Subject: DEVIATION REVIEW AND DECISION FORM

Section of ECM from Which Deviation is Sought: Appendix B Transportation Impact Study Guidelines Section B.1.3 Revisions and Updates

Proposed Nature and Extent of Deviation: LSC prepared a traffic impact study (TIS) for the entire Walden Preserve 2 development dated September 17, 2014. A transportation memorandum has been prepared for Walden Preserve 2 Filing No. 4. It is proposed that a full TIS update be postponed until the next filing (Filing 5) is submitted.

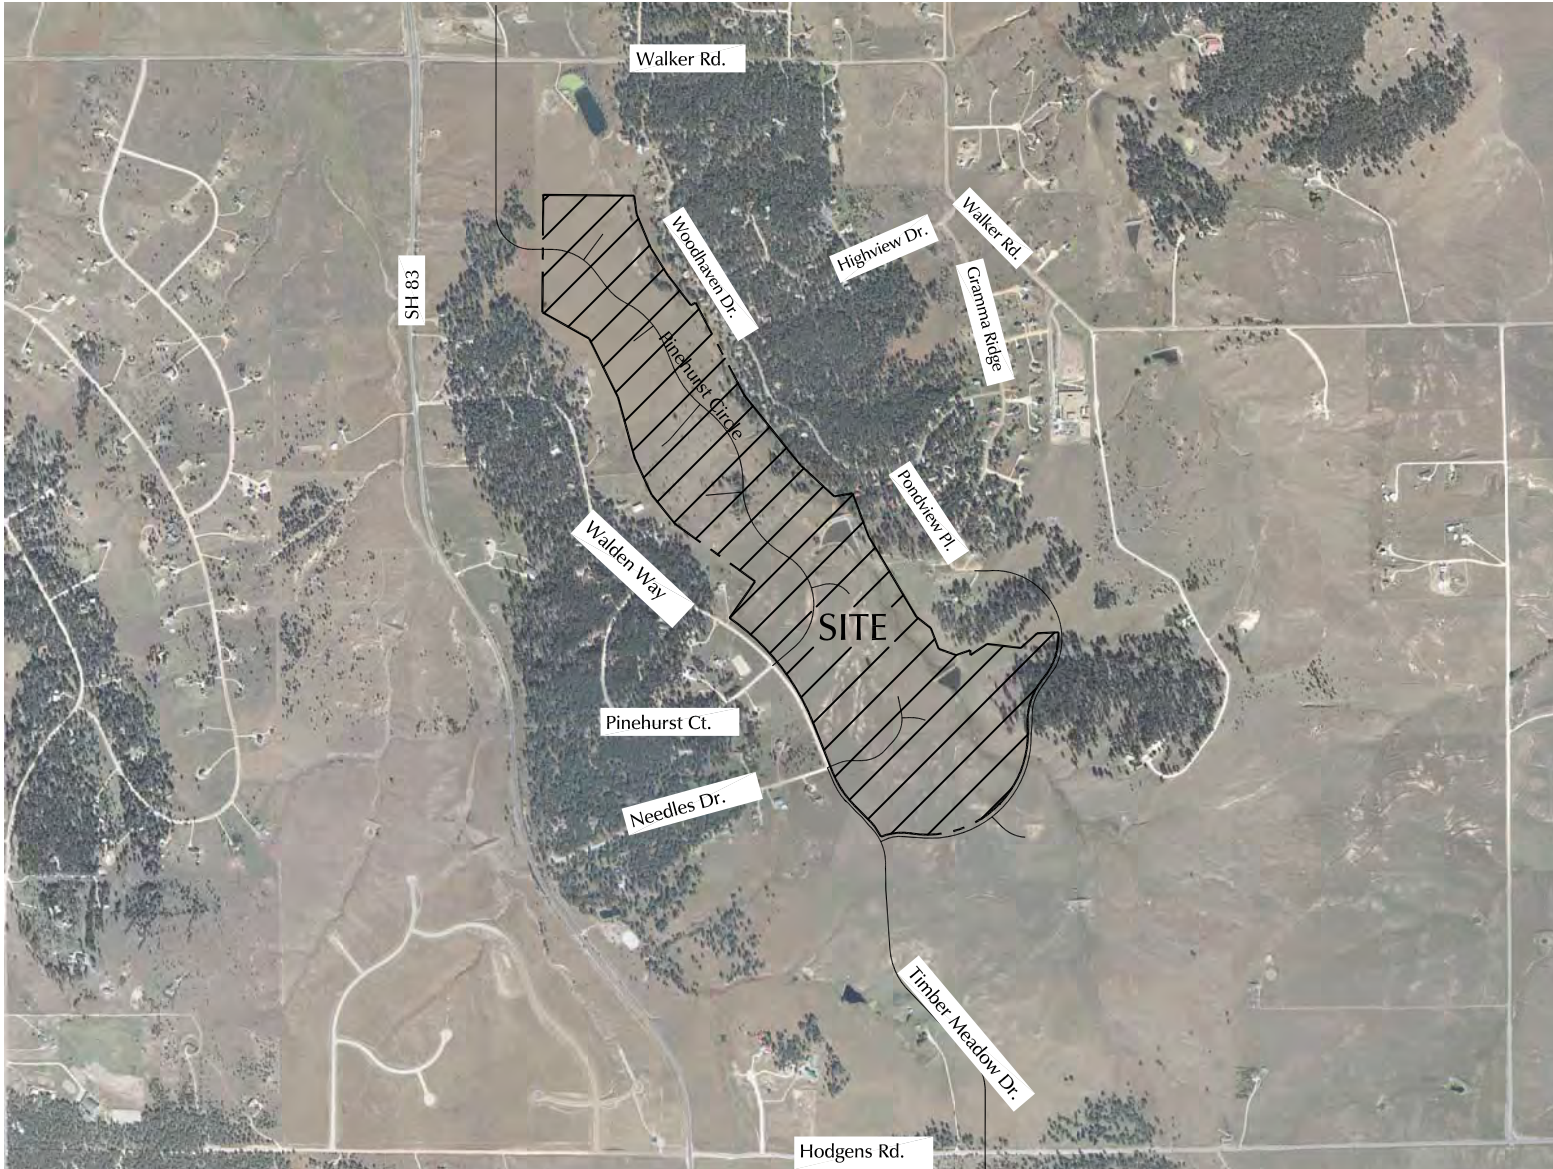
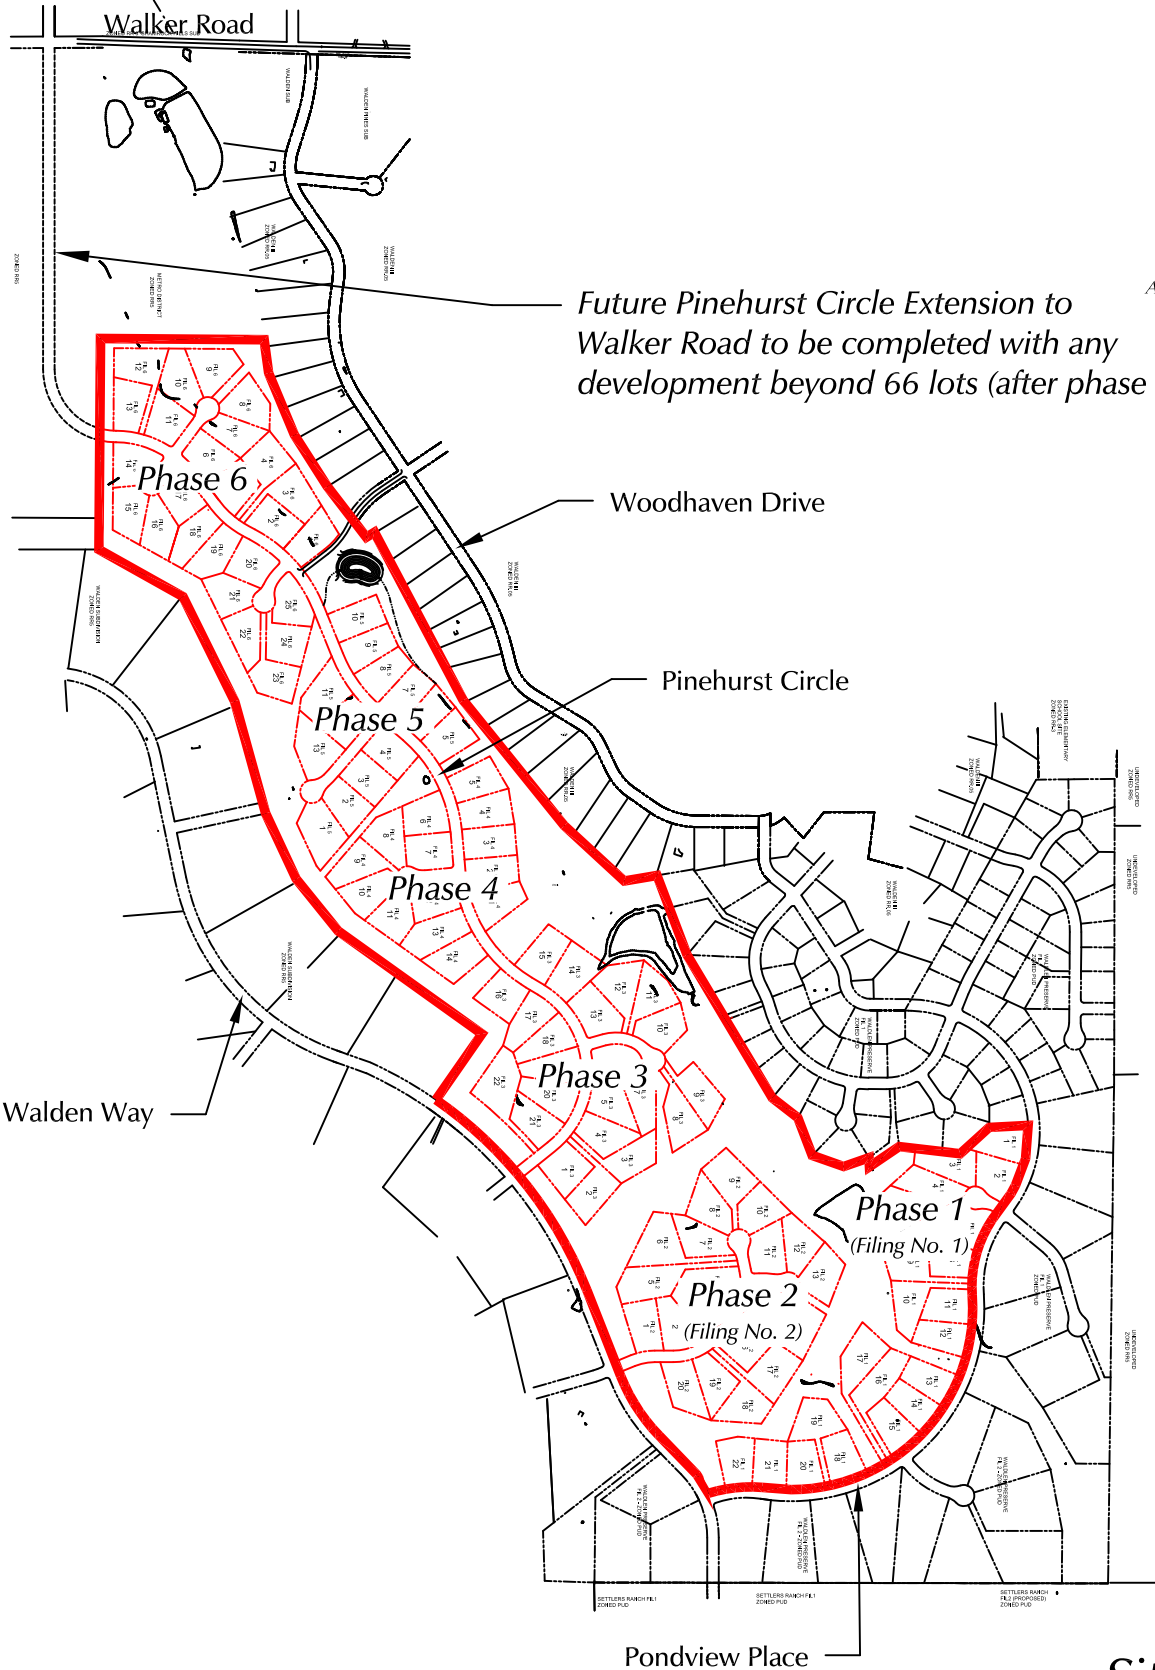
Attach an exhibit with this deviation request. Exhibit to show Filing 4, existing Filings 1-3, future filing and future road extension with the next filing.
